From: Lauren Wiltshire [REDACTED]
Sent: 24 May 2019 10:35
To: Simon Davis <Simon.Davis@arun.gov.uk>; Laura Gibbons <Laura.Gibbons@arun.gov.uk>
Subject: RE: Planning Consultation on FP/42/19/DOC

Engineers Comments Regarding Condition 7

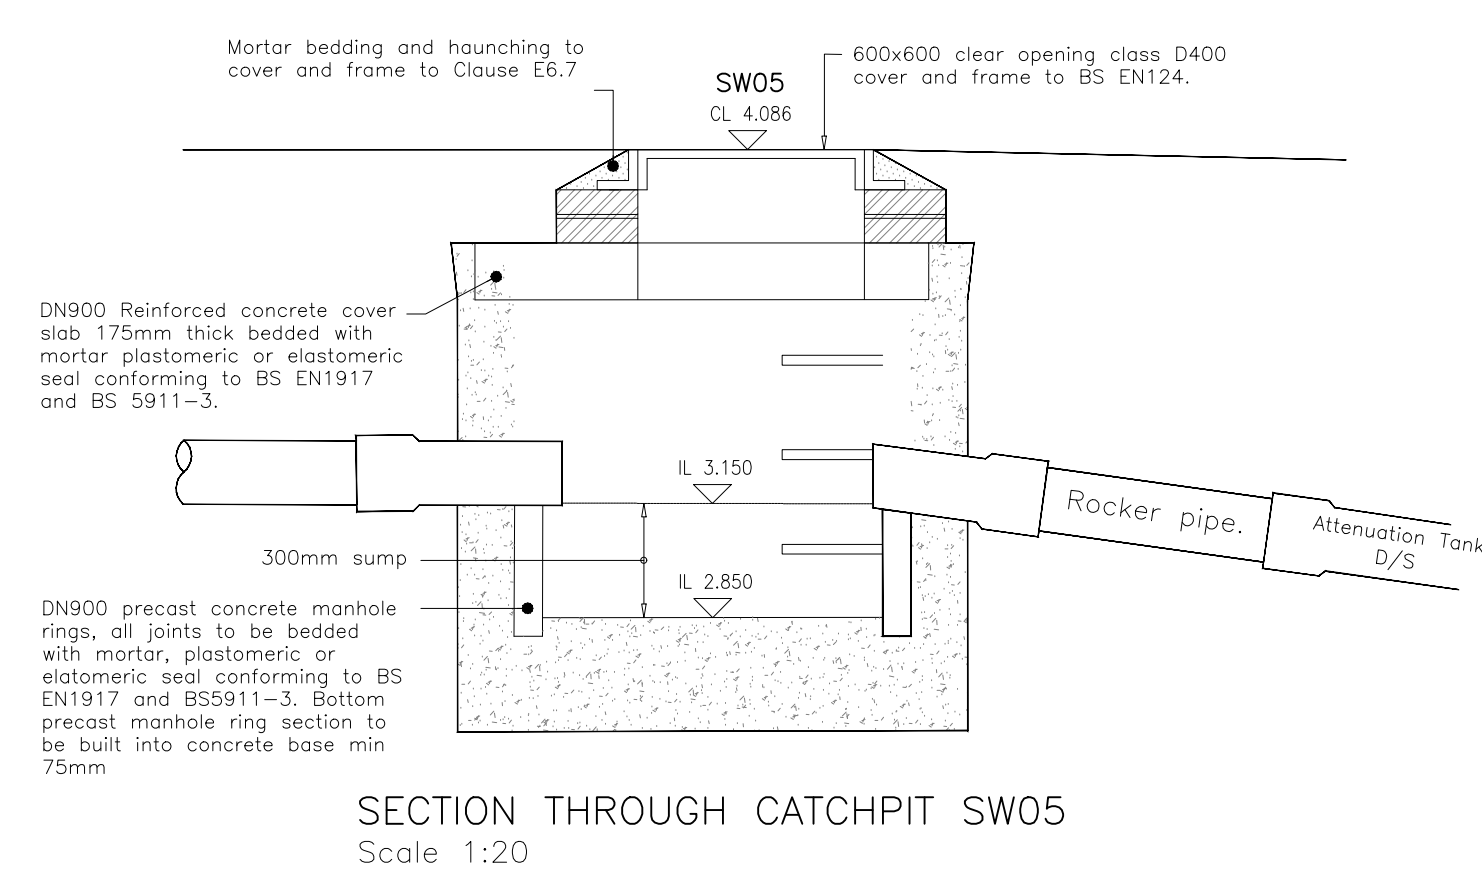
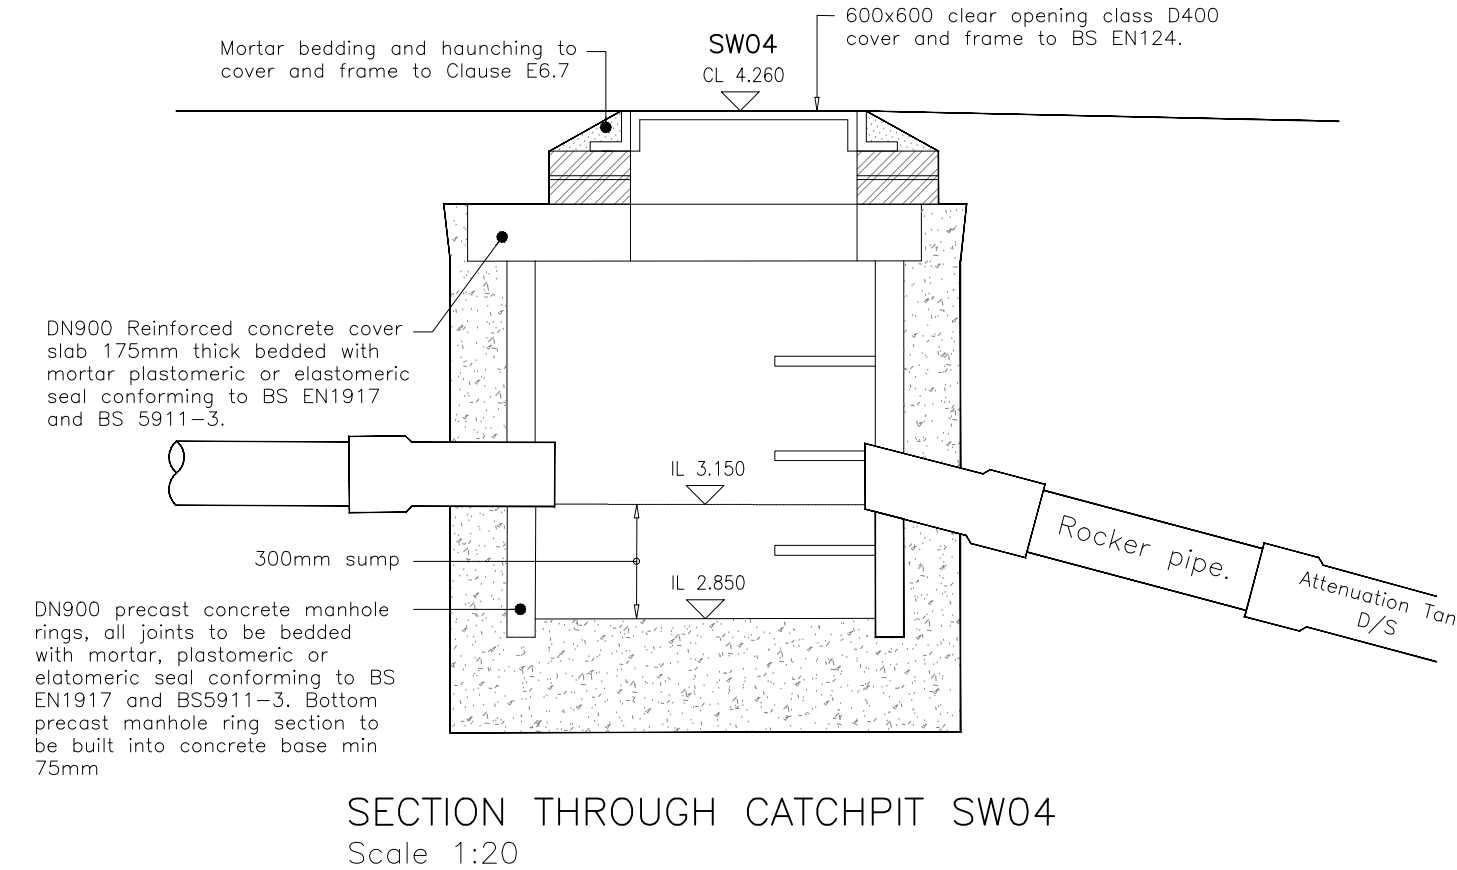
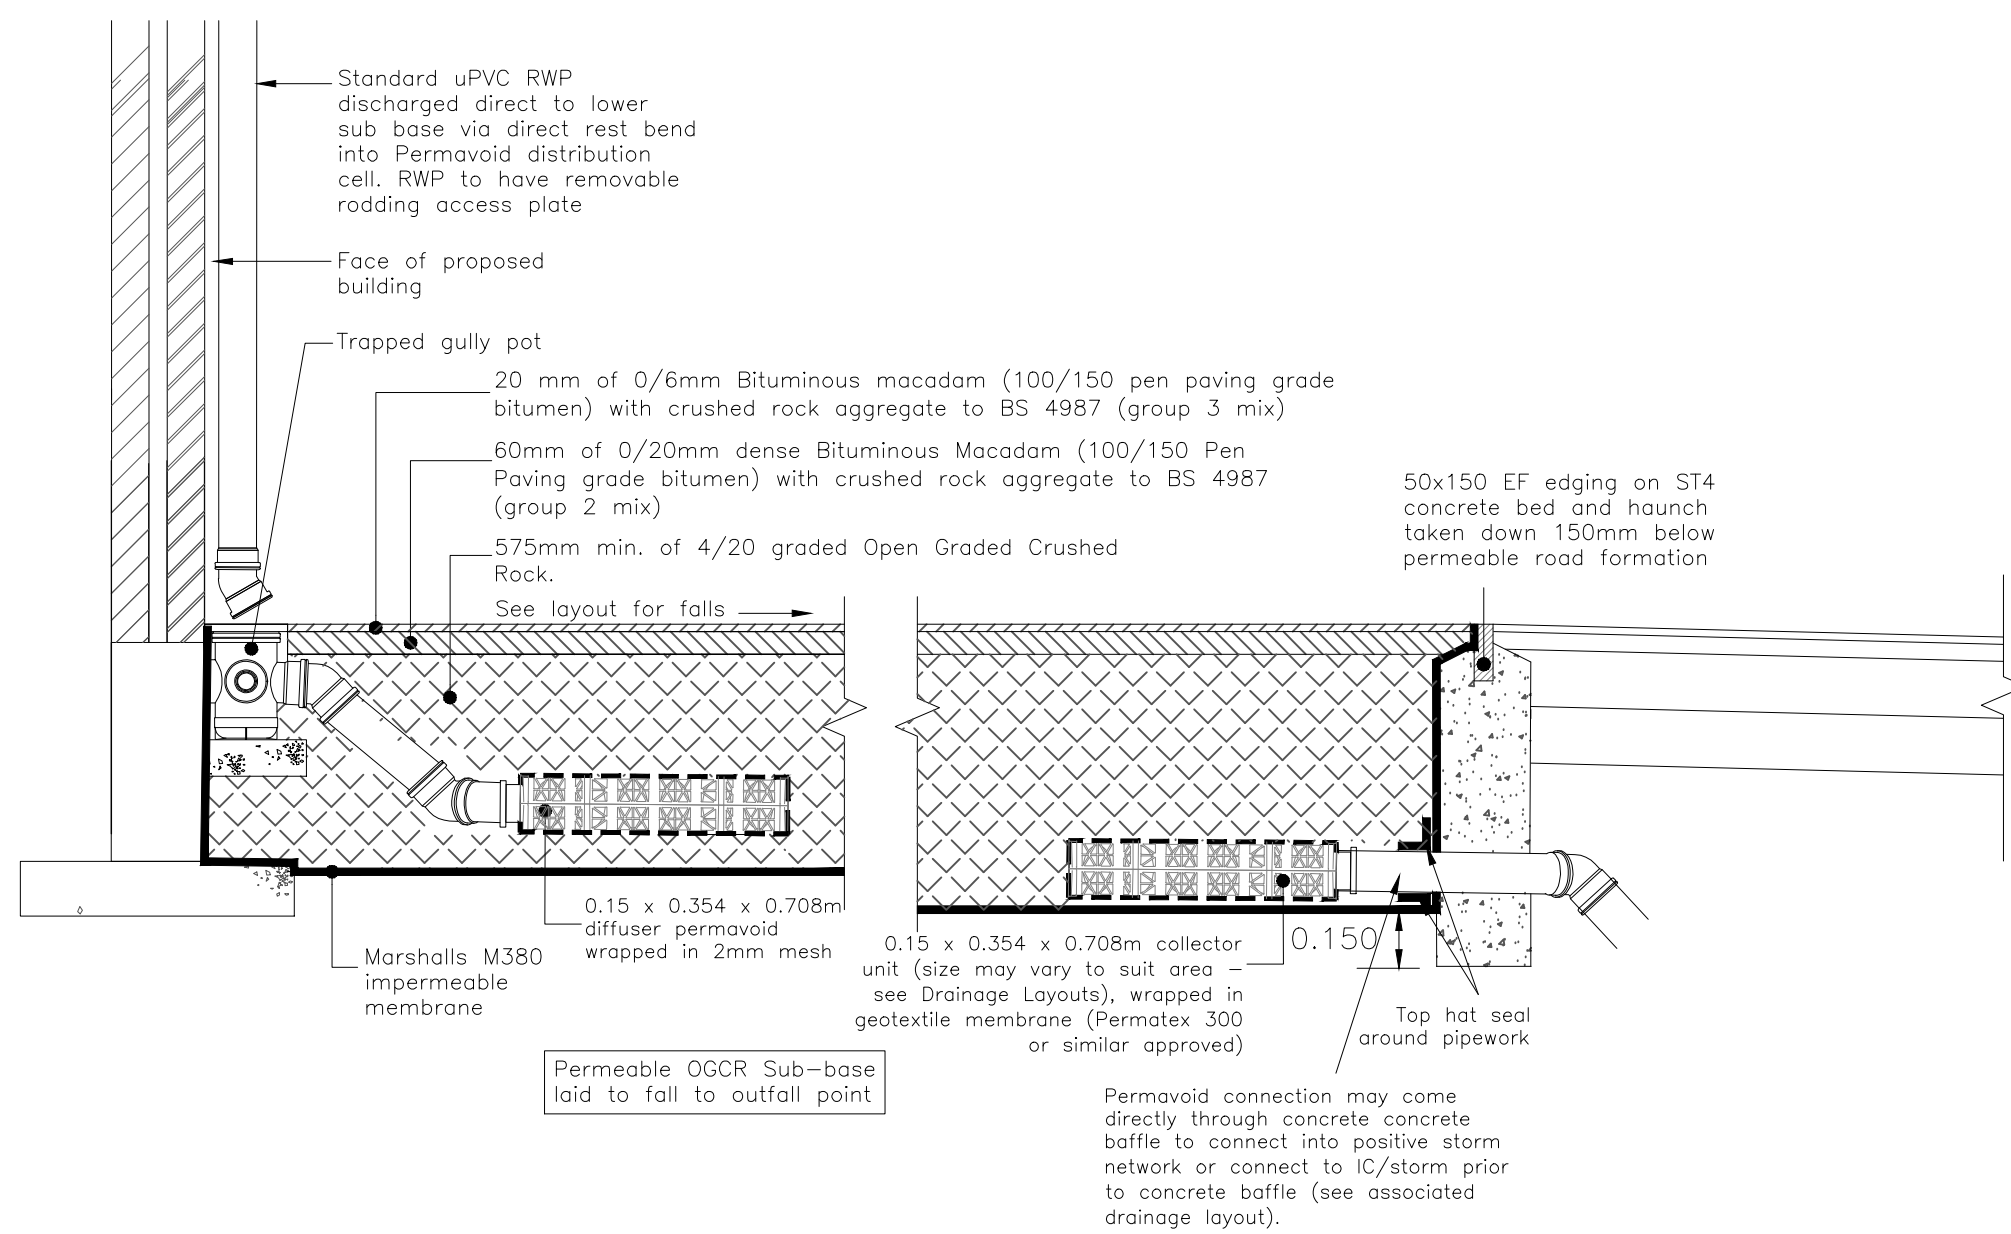
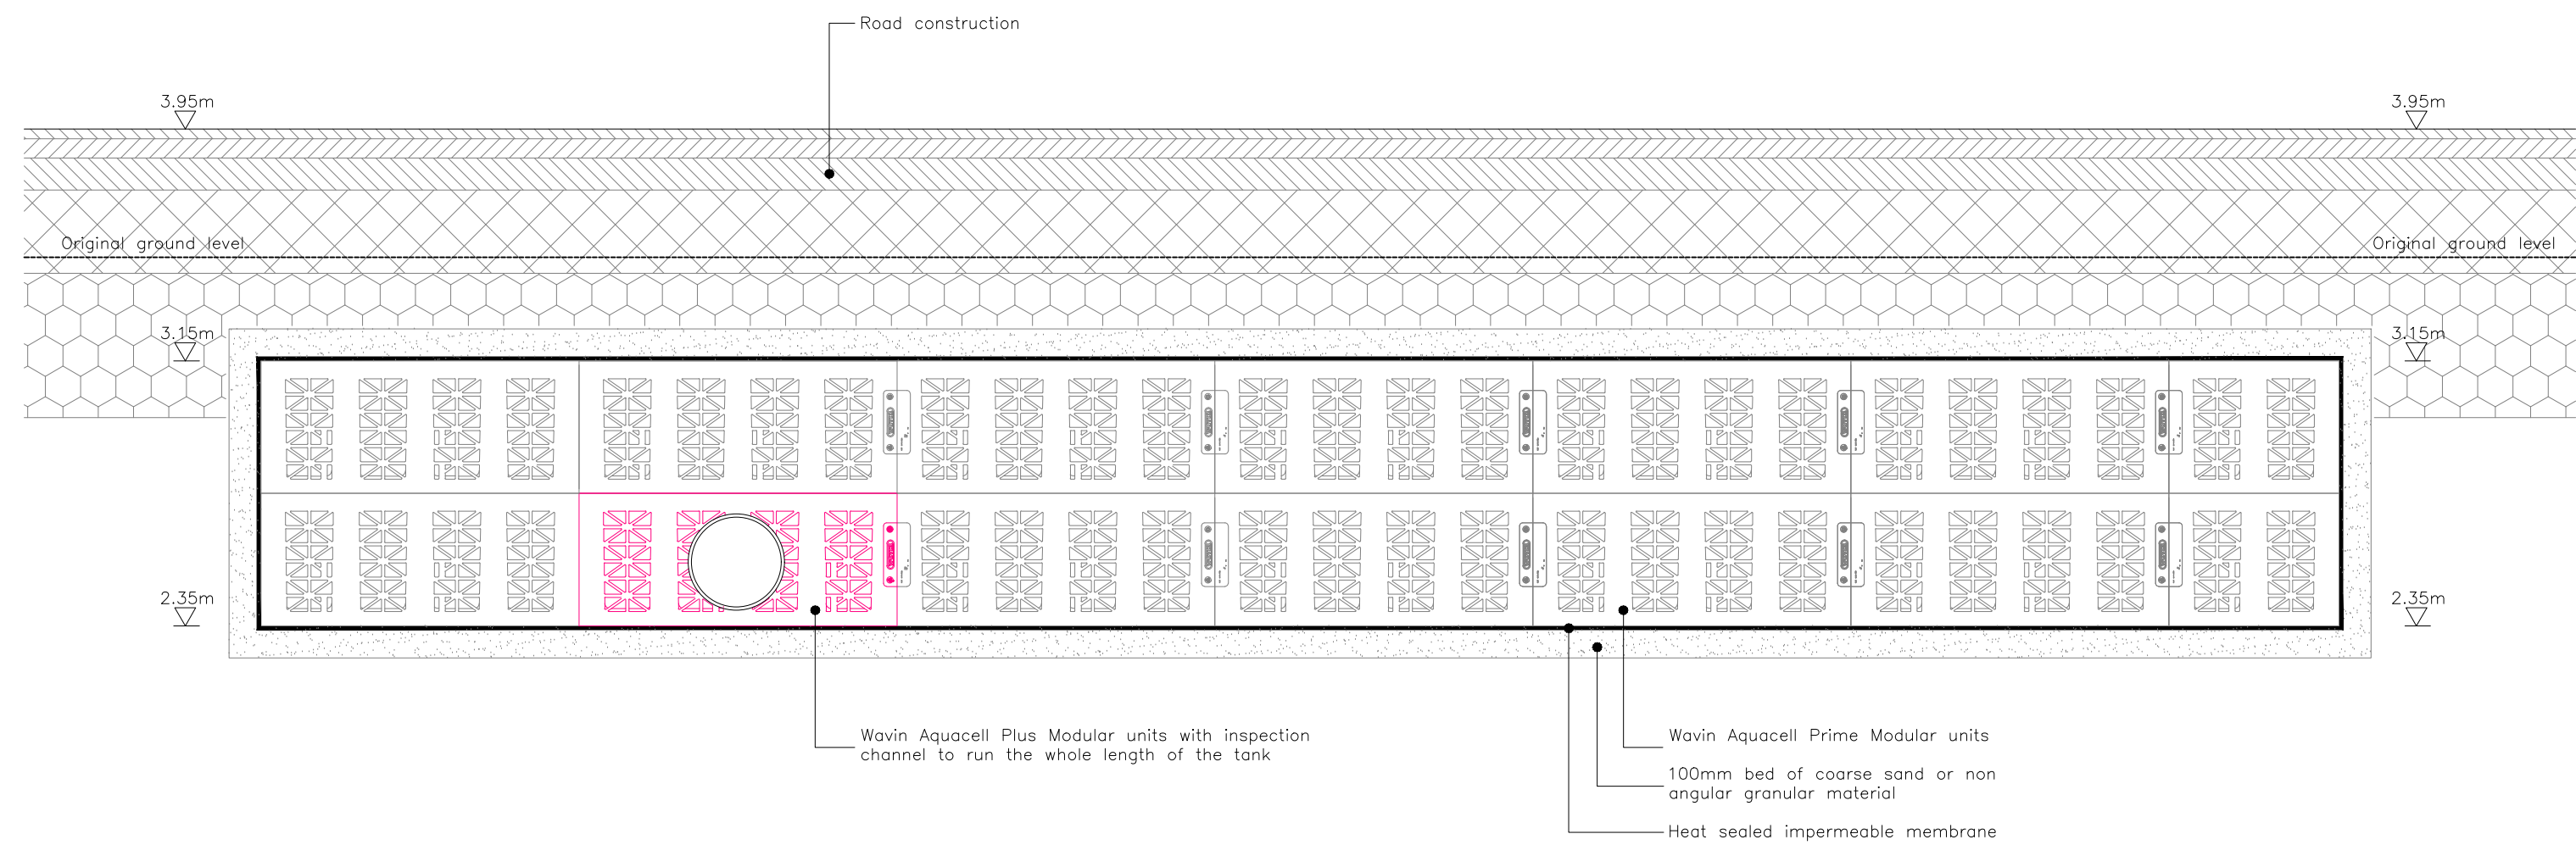
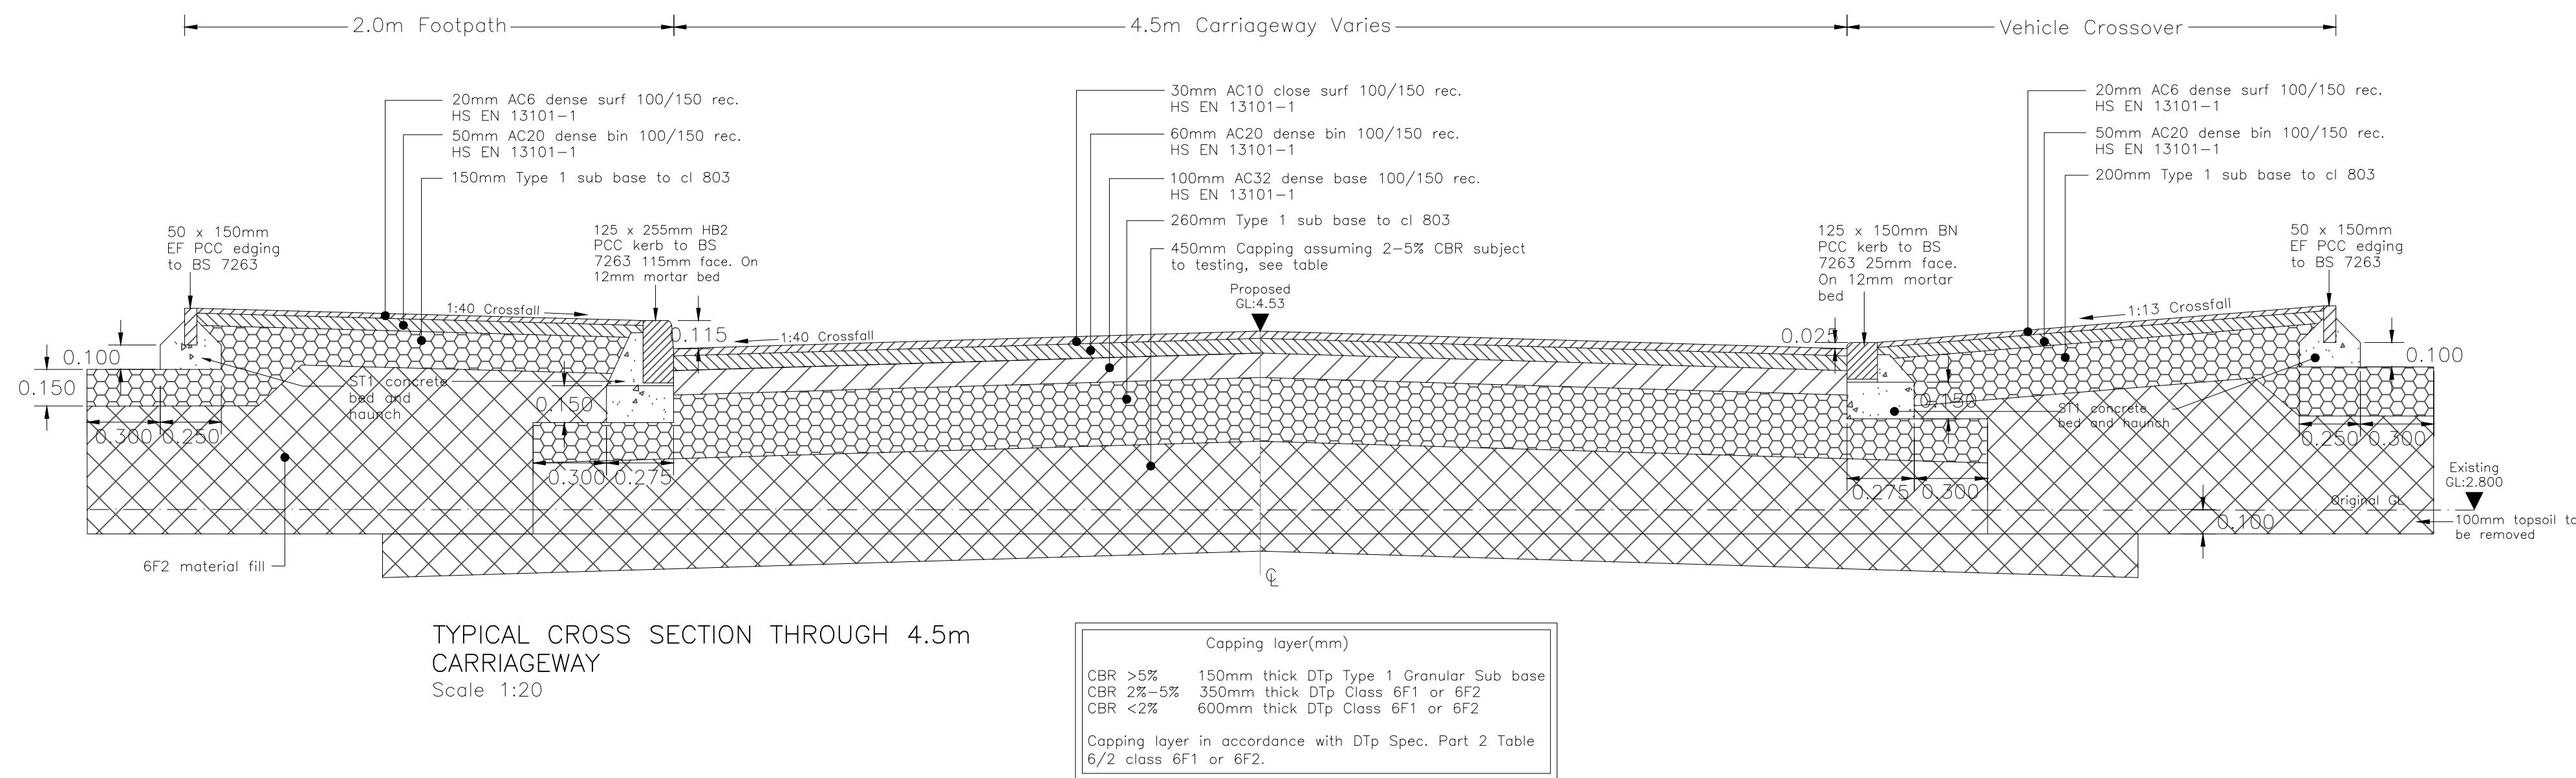
1. Catchpits must be provided upstream of all connections into the attenuation tank.
Please refer to drawing 5782:23 Construction Details demonstrating manhole SW04 and SW05 should be installed with 300mm deep catchpits.
